Ref: C3489
10 June 2026

Re: Engineers Comments Regarding Surface Water Drainage- 16 Swanbourne Road Littlehampton BN17 6HS. Erection of 1 No single storey dwelling with car parking and provision of driveway and car parking for No. 16 Swanbourne Road (resubmission following LU/96/25/PL).

Application reference: LU/98/26/PL

Trench soakaway using Polystorm-R Geomodular units

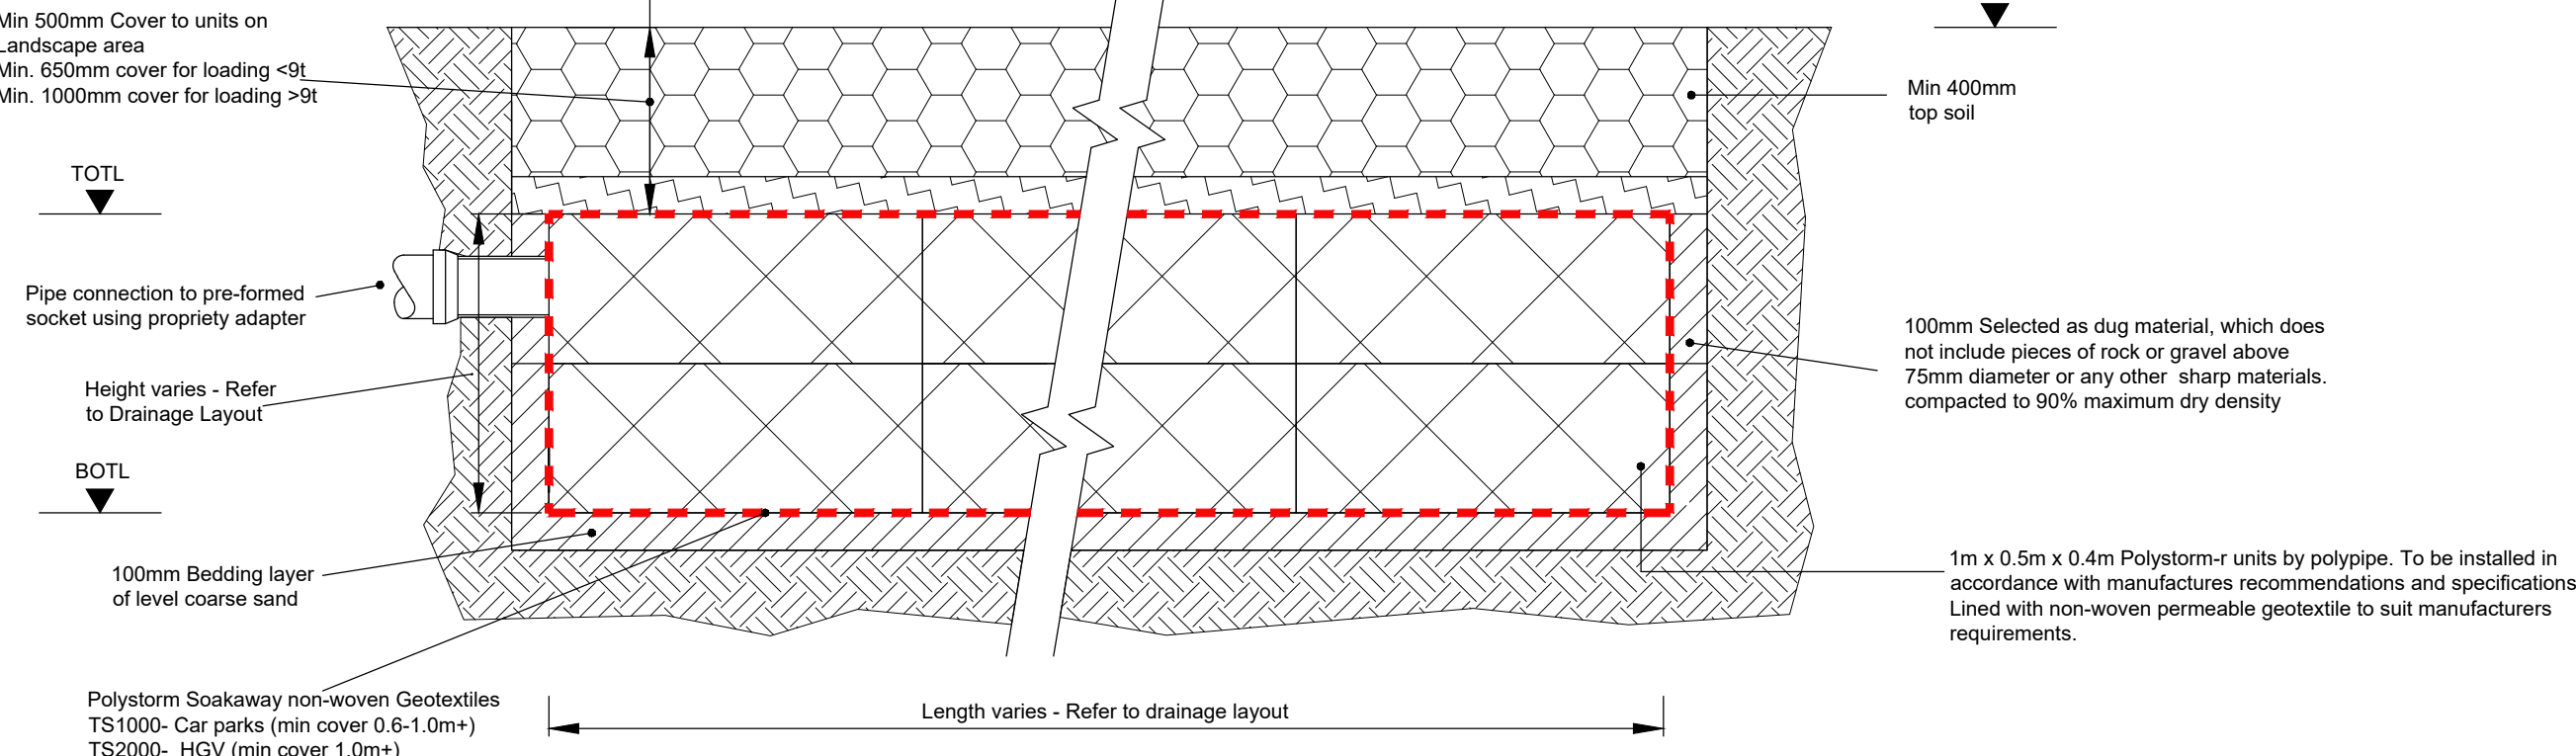
- 3.3. The half drain times during the 3.3% AEP storms need to be evidenced in the calculations.

Noted. For clarity, separate 1 in 30-year storm event calculations have been provided, clearly showing the maximum water level within the tank at 5.611 mAOD. The model demonstrates that after 304 minutes the tank drains to below half full. The storage tank operates between levels 5.300 mAOD and 5.700 mAOD. Please refer to attached 1 in 30-year storm event calculations.

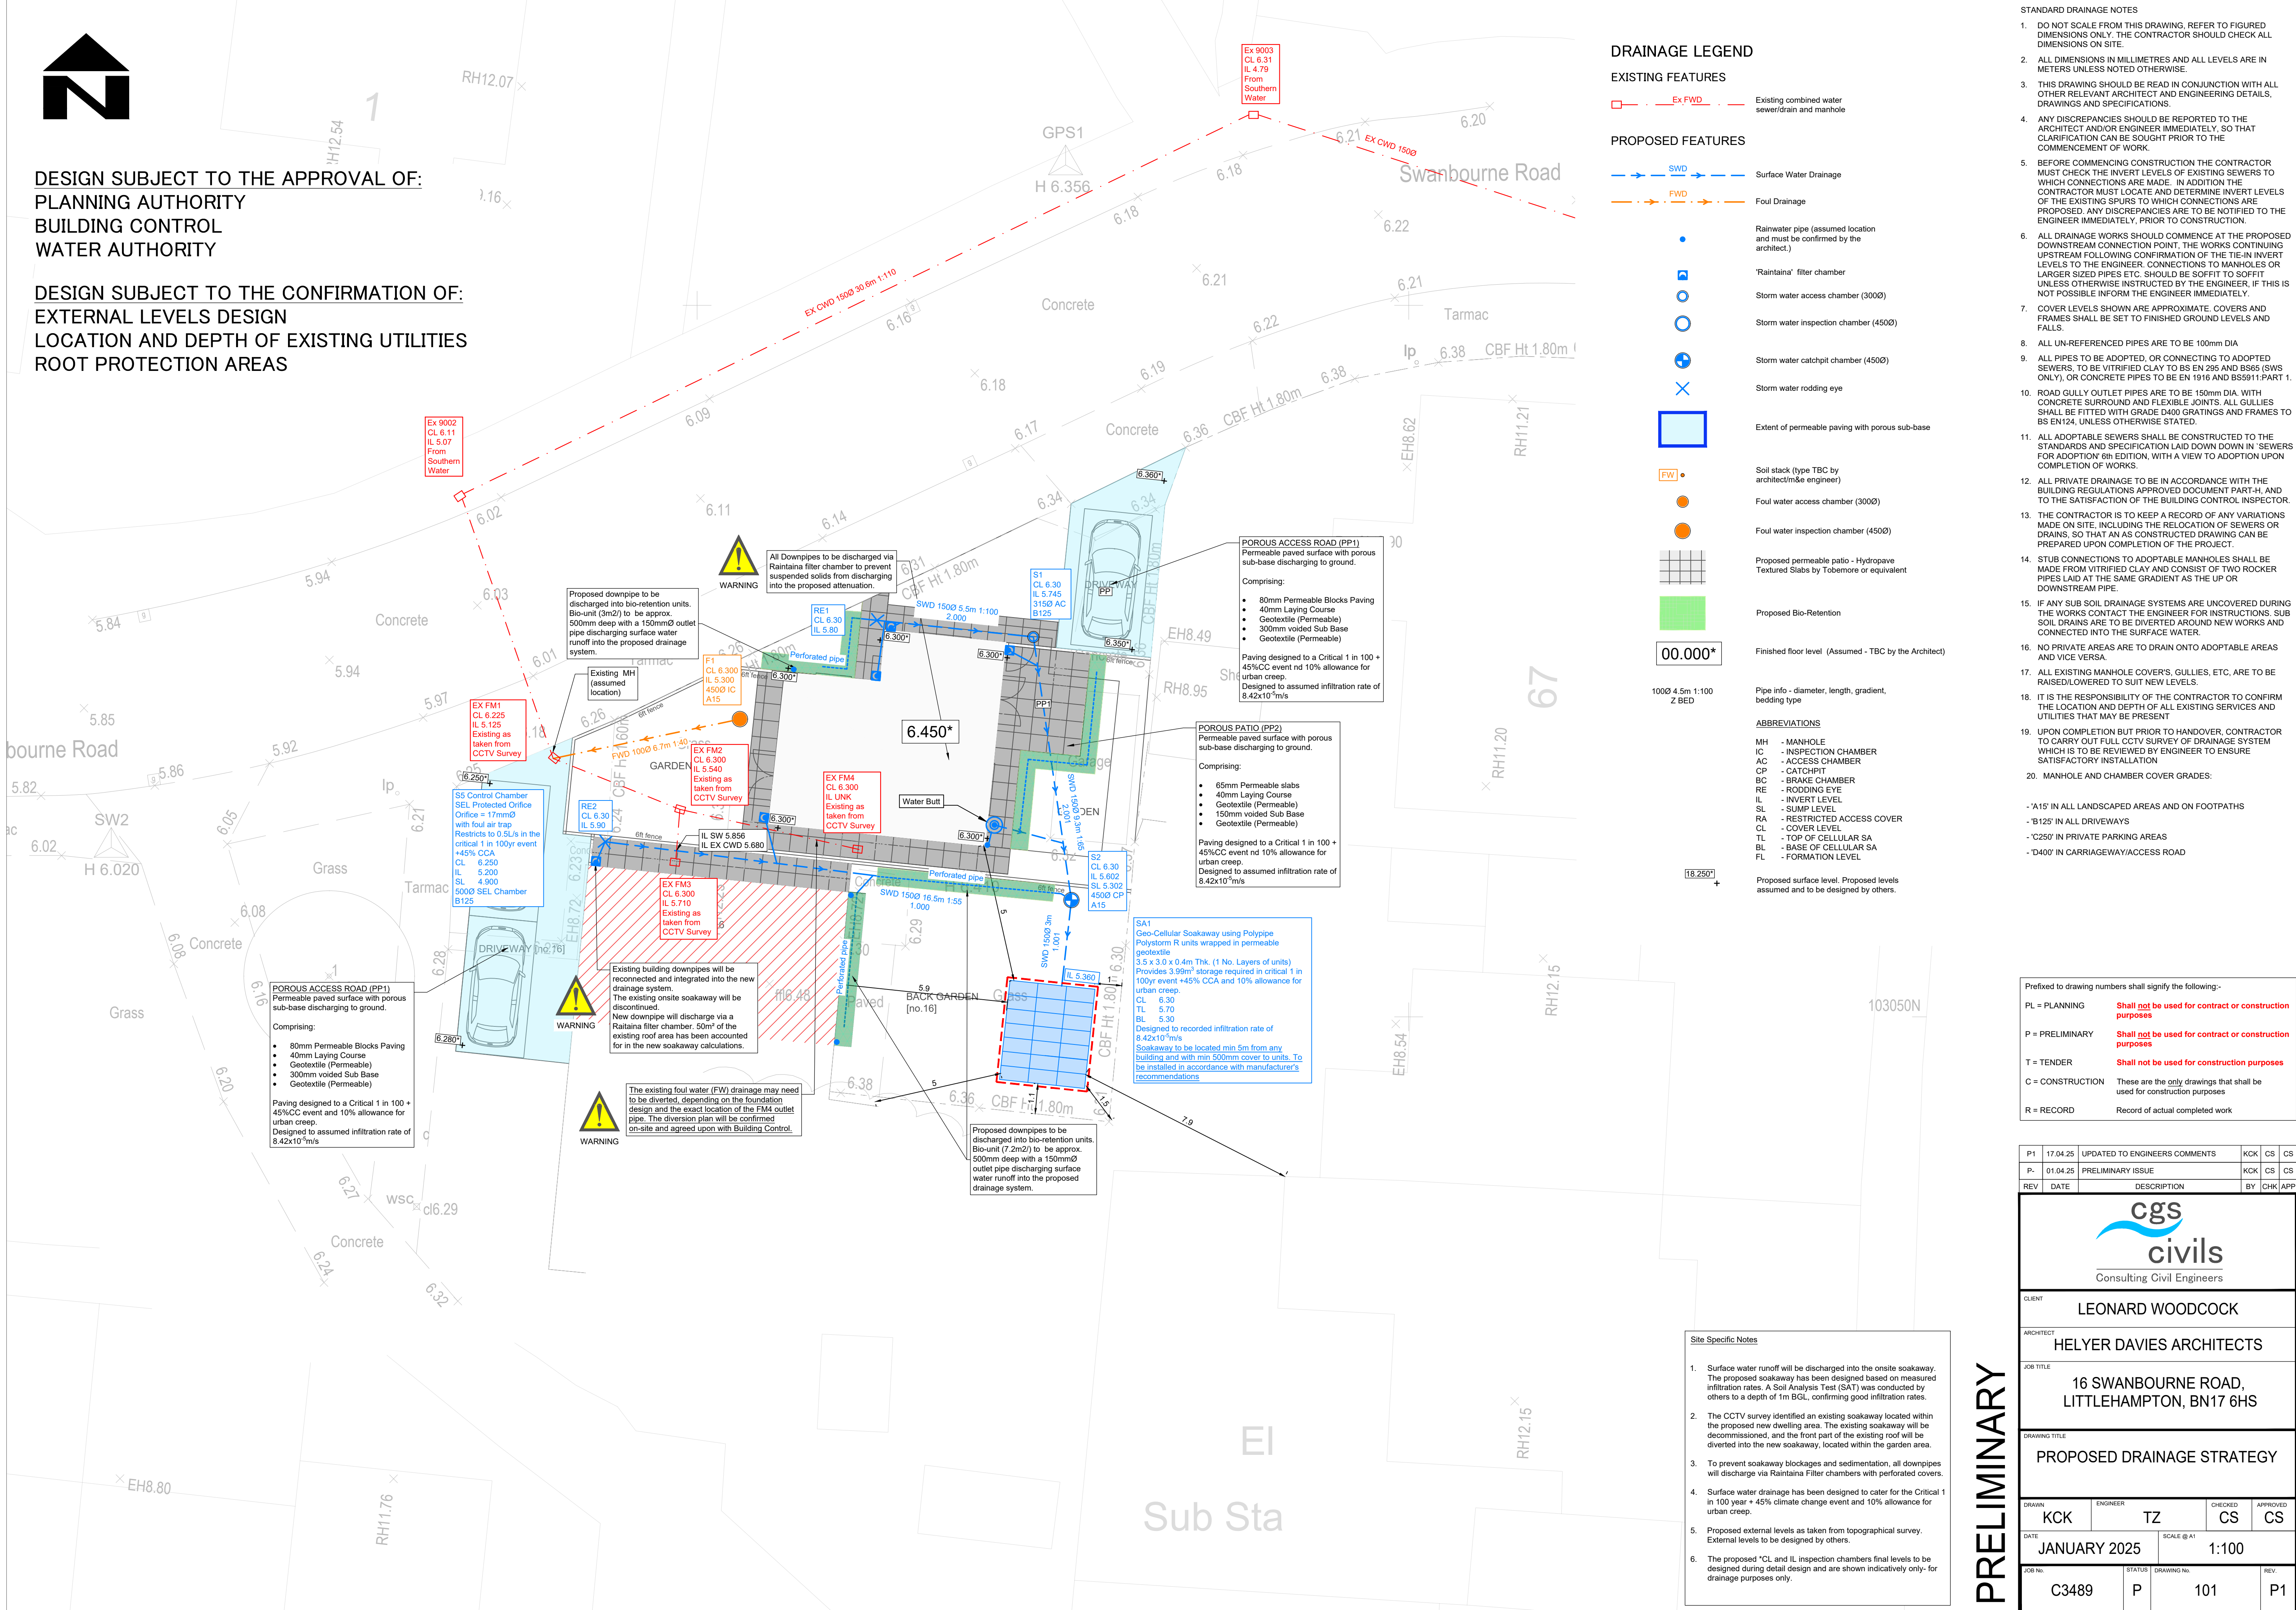
- 1.2. The proposed runoff destination is now solely discharge to ground via infiltration although a flow control chamber is still shown on the drainage layout and in the calculations, but it appears to be redundant and not part of the drainage design.

- 3.2. There is a flow control chamber, S5, including on the layout and in the calculations which appears to be orphaned/redundant and should be removed for clarity.

Noted and updated. The flow control chamber has been removed from both the drainage calculations and drawings, and the design now solely comprises discharge to ground via infiltration.

Noted and updated. The flow control chamber has been removed.
